359 Kent Street, 436 and 444 MacLaren Street, Ottawa

Planning Rationale Addendum No. 2
Official Plan and Zoning By-law Amendment
July 28, 2023

DRAWING TITLE:
ELEVATIONS

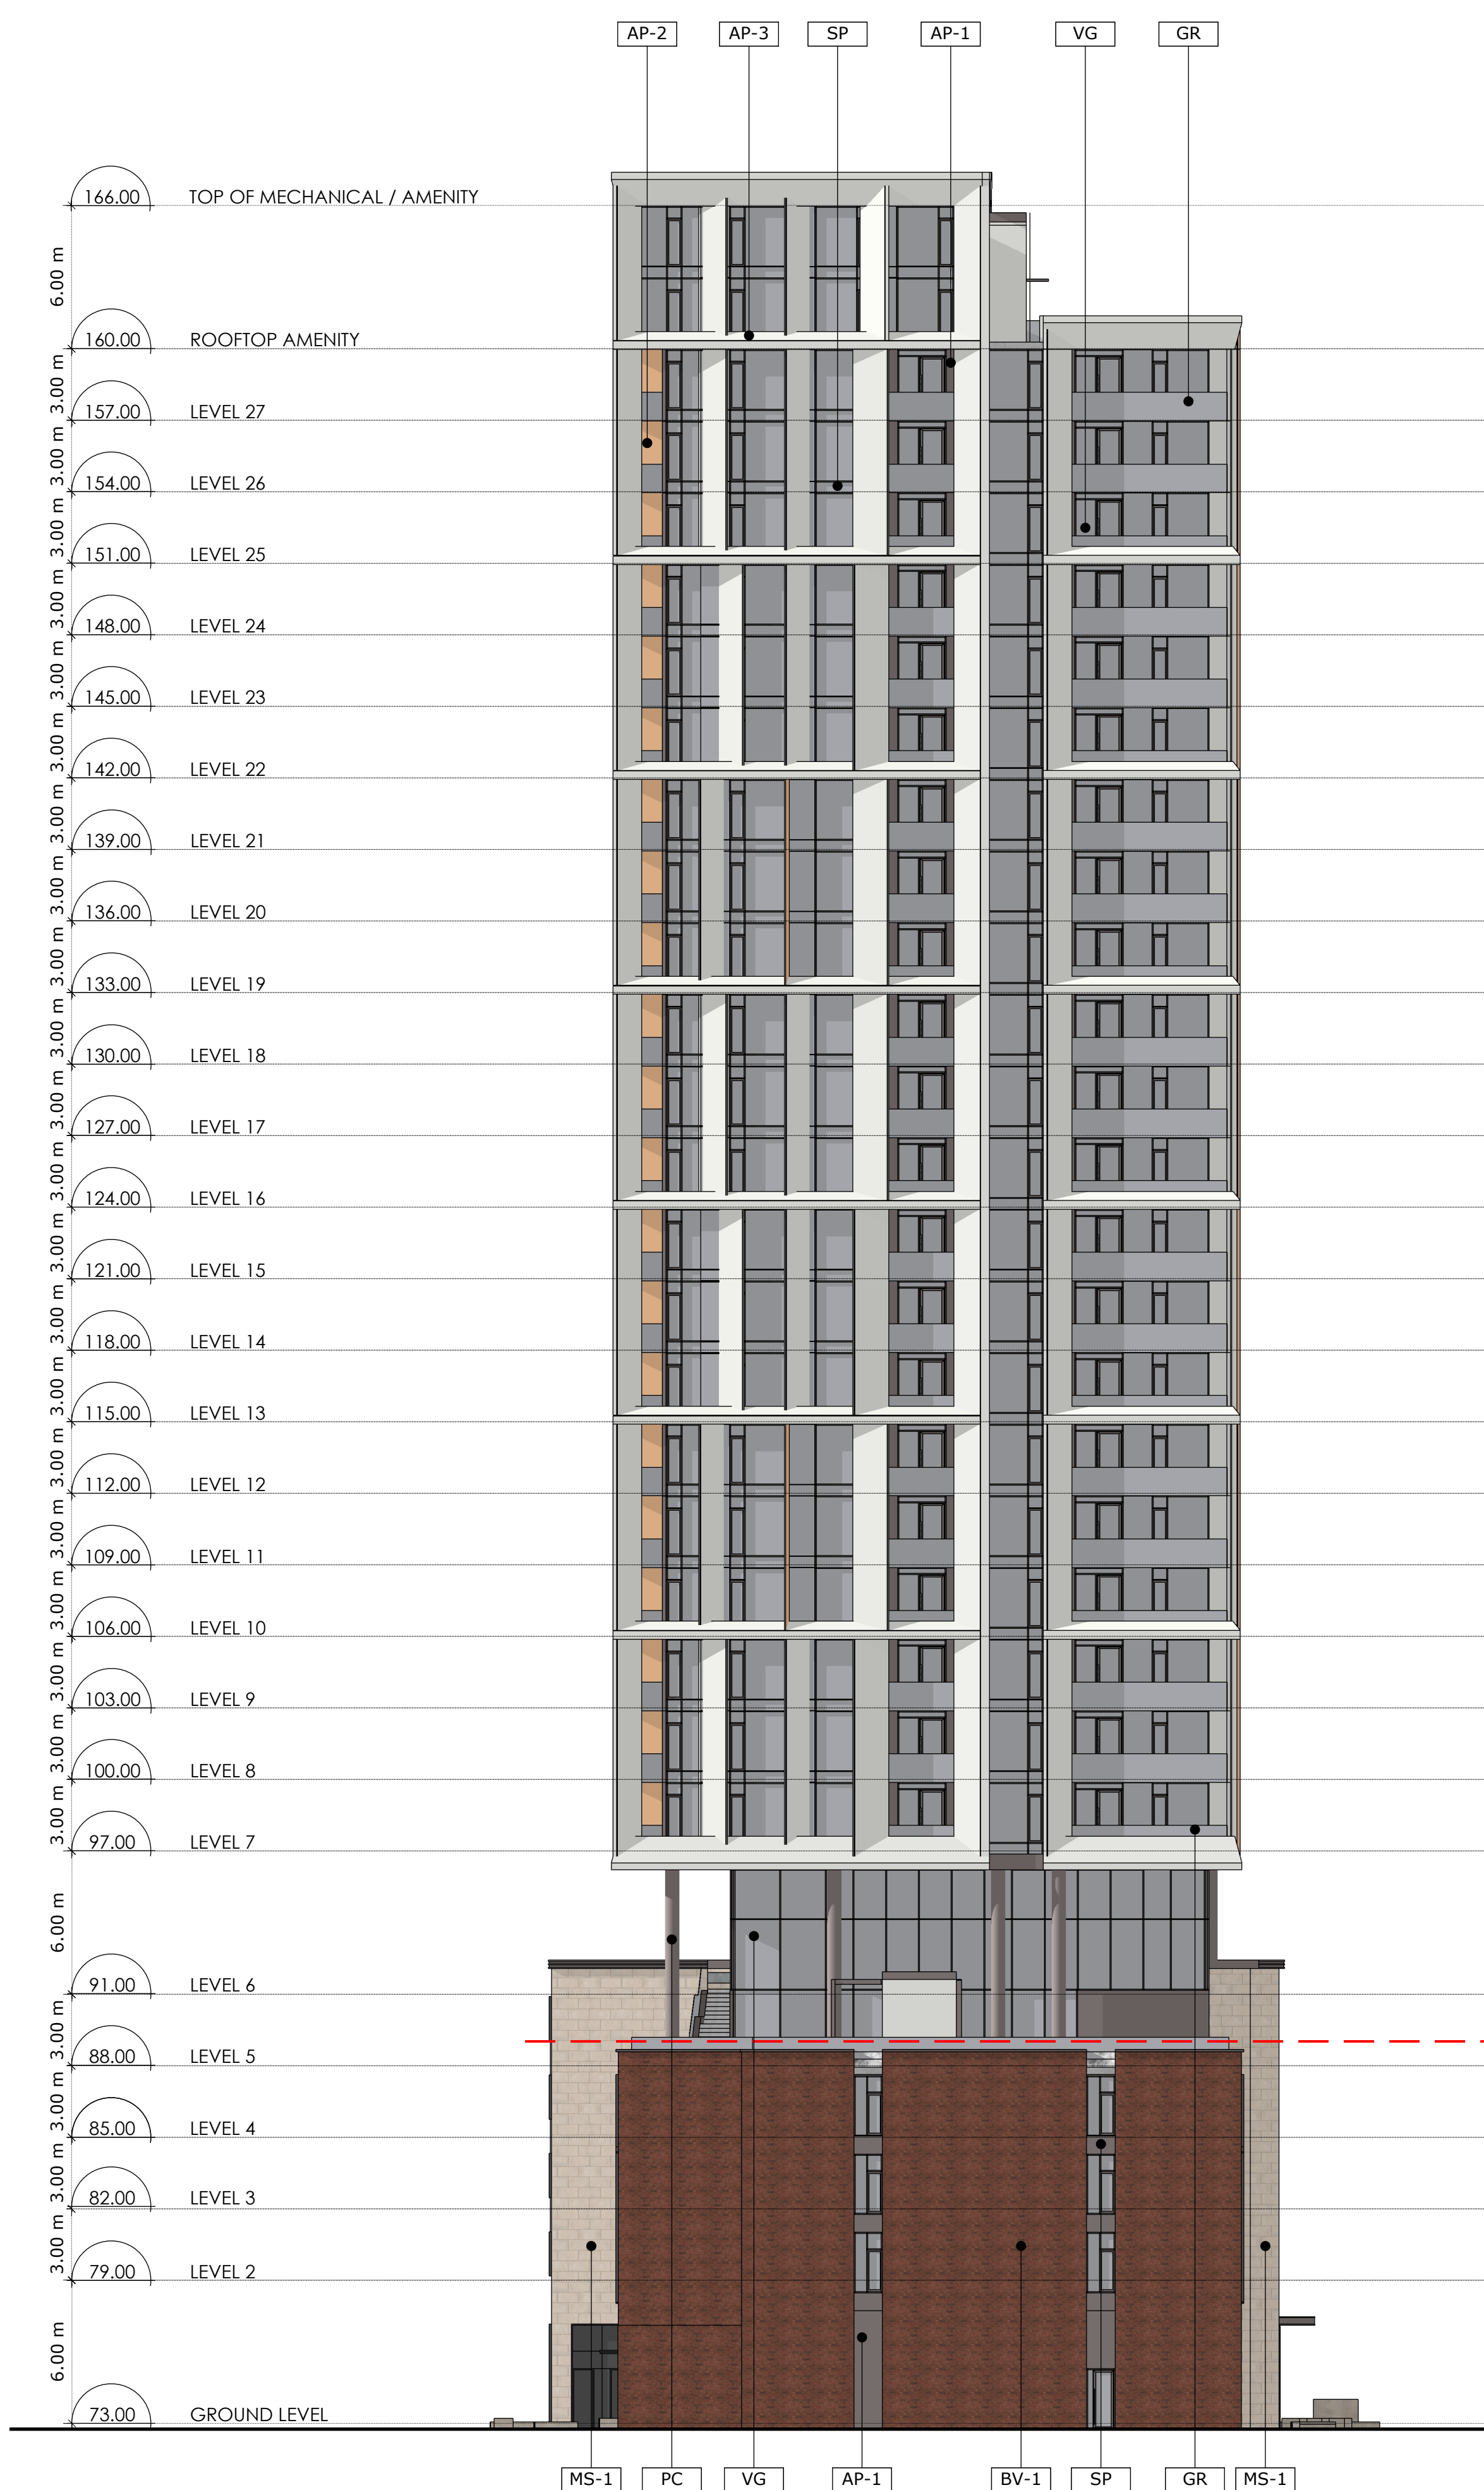
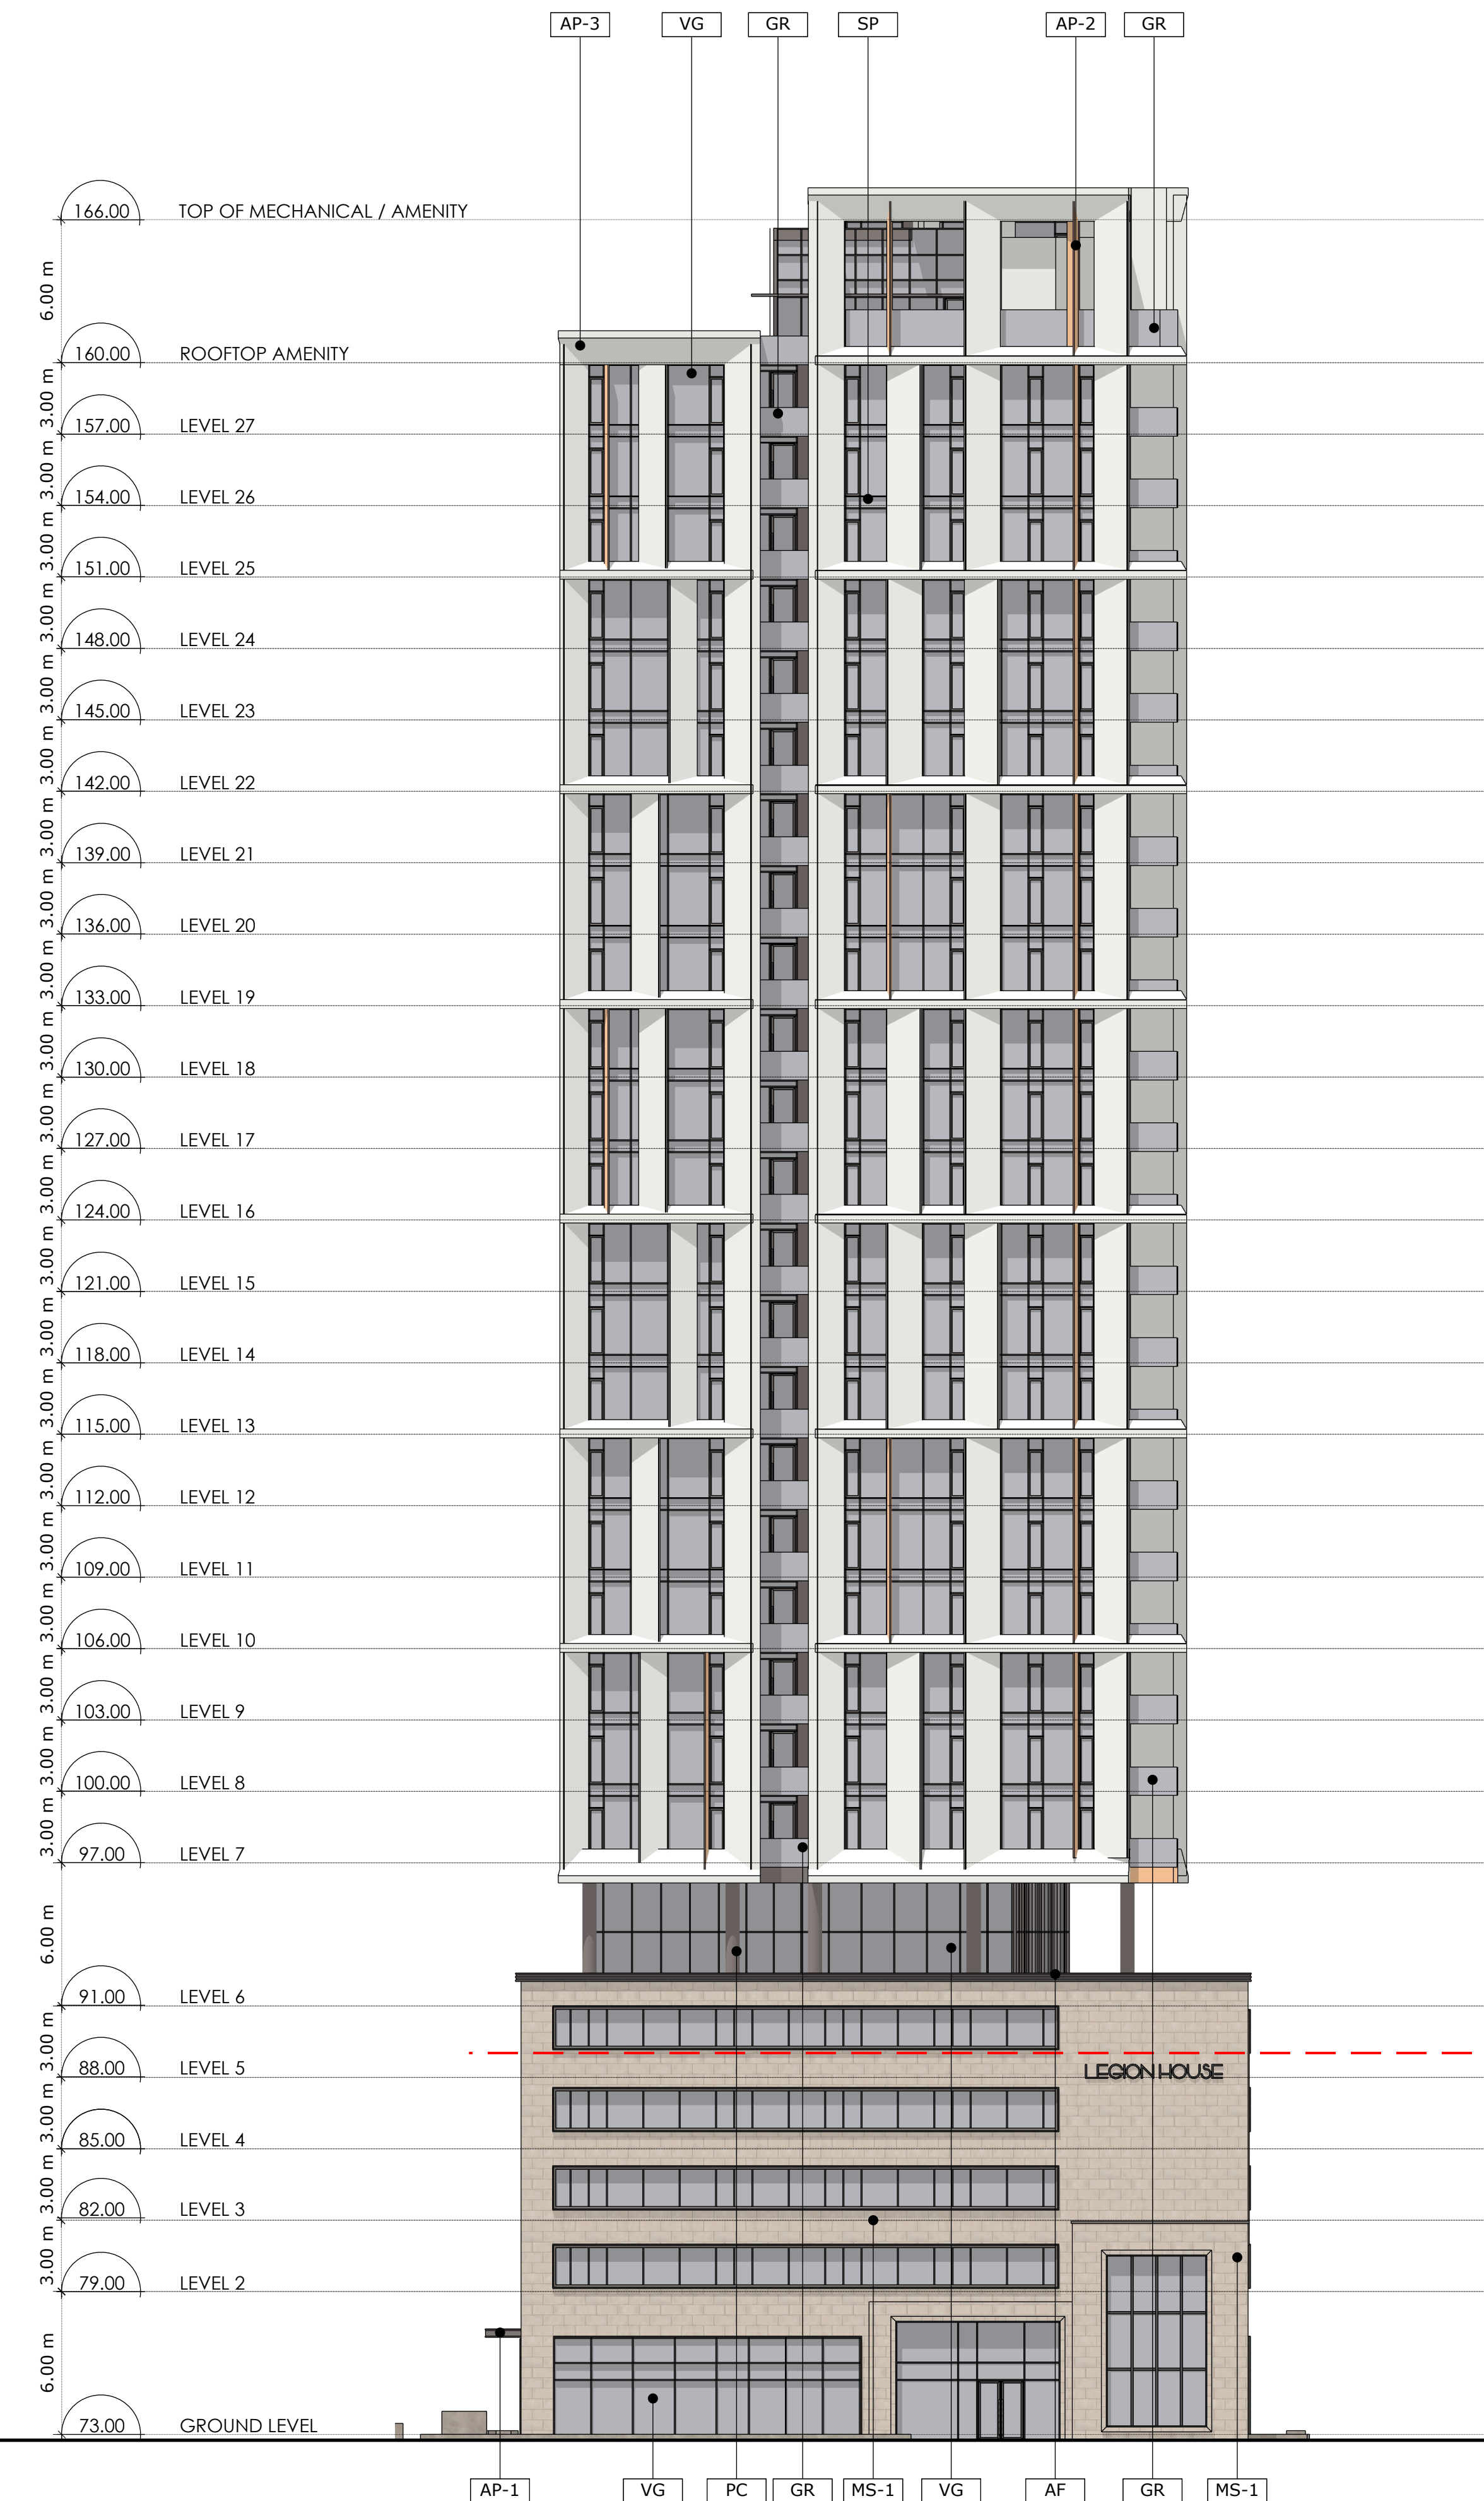
- 10 The policies for landmark buildings restrict the building height up to 27 storeys. Height in excess of 27 storeys will not be considered or supported by Staff as previously discussed on several occasions.

- 14b Furthermore, the five-storey podium should introduce elements of transition to provide better transition to the east, such as a stepback on the east side on at the 3rd or 4th storey.

- 14c Staff are of the opinion that the podium rooftop canopy negatively impacts the revised podium height and transition of the proposed development to the planned and existing low-rise context and recommend that this be removed from the development proposal.

The height of the proposed development has been reduced to 27 storeys to reflect the feedback from the public and City staff.

The podium of the development has been further reduced from the original 8-storey height, and the previous 5-storey height, to a current height of 4-storeys. This provides a stepped transition from the existing low-rise context through the 4-storey eastern podium to the 5-storey height of the retained 359 Kent Street façade. The canopy atop the eastern podium has also been removed to reduce the perceived massing of the podium.

The rooftop canopy has been removed to facilitate better transition to the planned and existing context.
